**Preliminary Drainage Report
Meadow Lake Industrial Phase 1
El Paso County, Colorado**

April 2024

PCD File No. SP236

DRAINAGE MAPS  
 PROPOSED DRAINAGE MAP

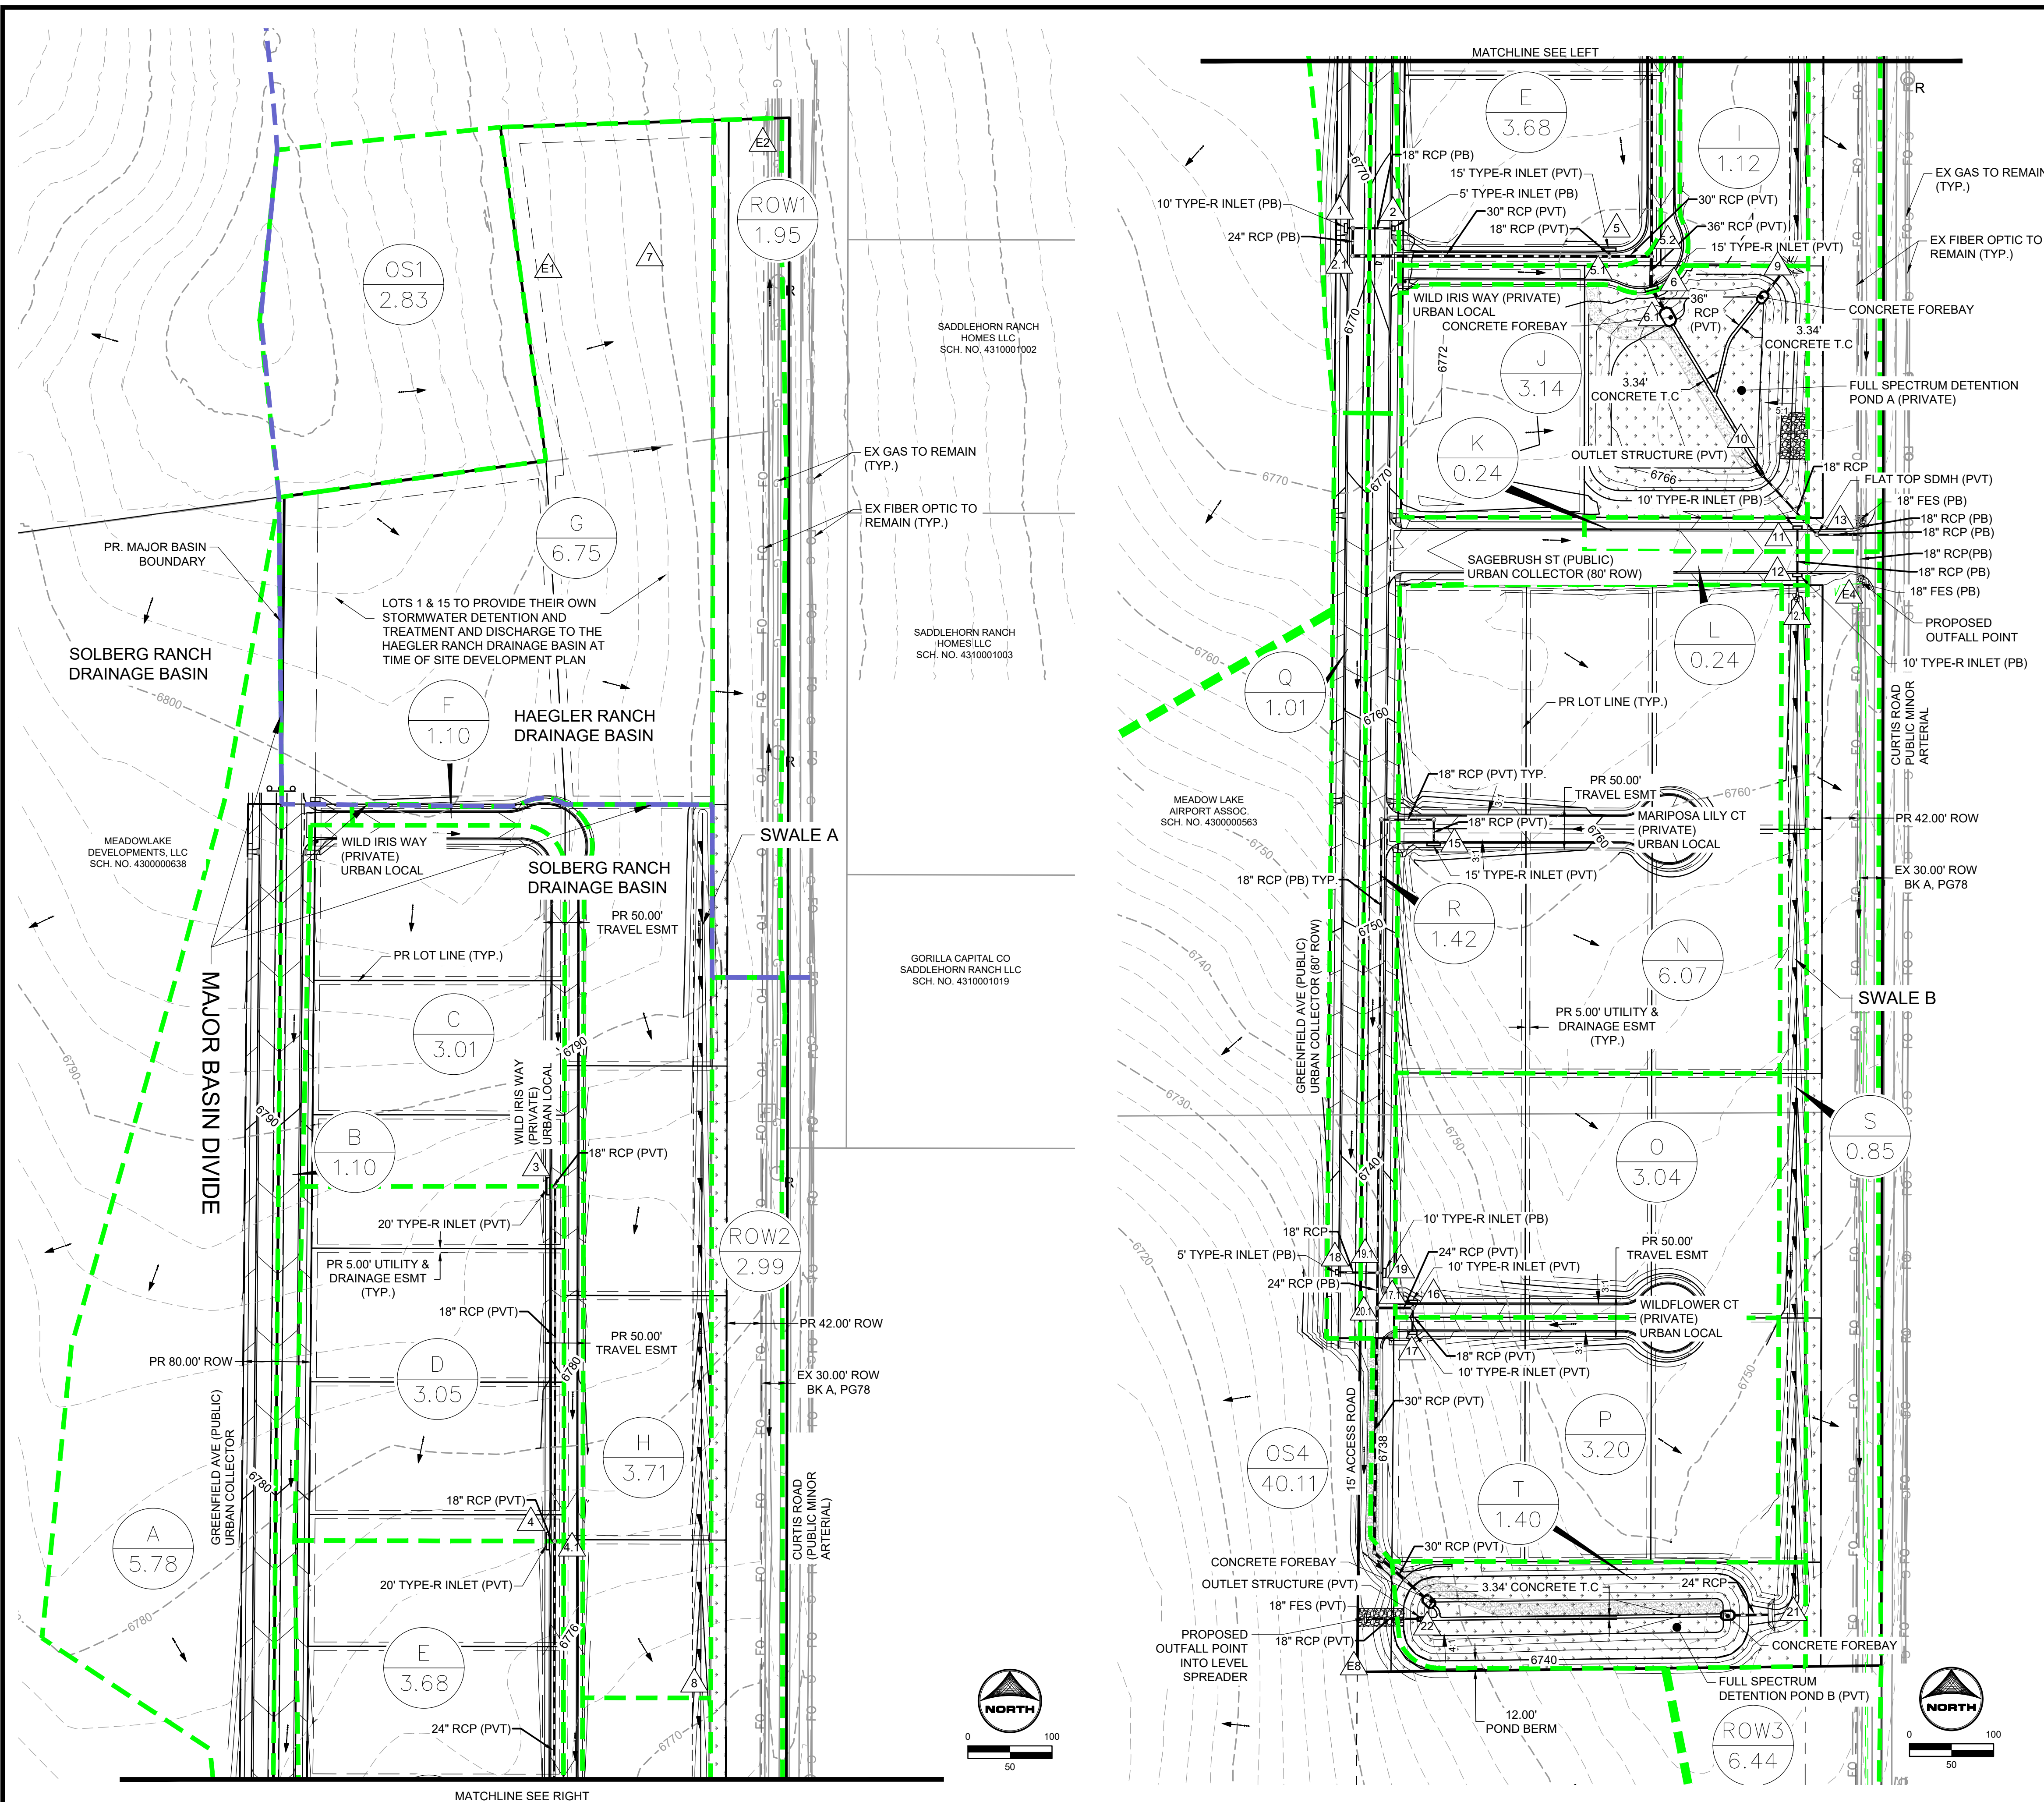
please clarify where flows from DP 7 are conveyed to. Is it conveyed to DP9?

Please clarify as there appears to be a storm pipe that collects flow from swale and then conveyed to the pond in the drainage plan.

Please account for the Curtis road improvements (widening and turn lane) required by this development. Coordinate with the traffic engineer. Be sure to address increase in flows/detention and water quality for these improvements

please also identify the ultimate outfall of the pond (i.e. the un-named tributary)
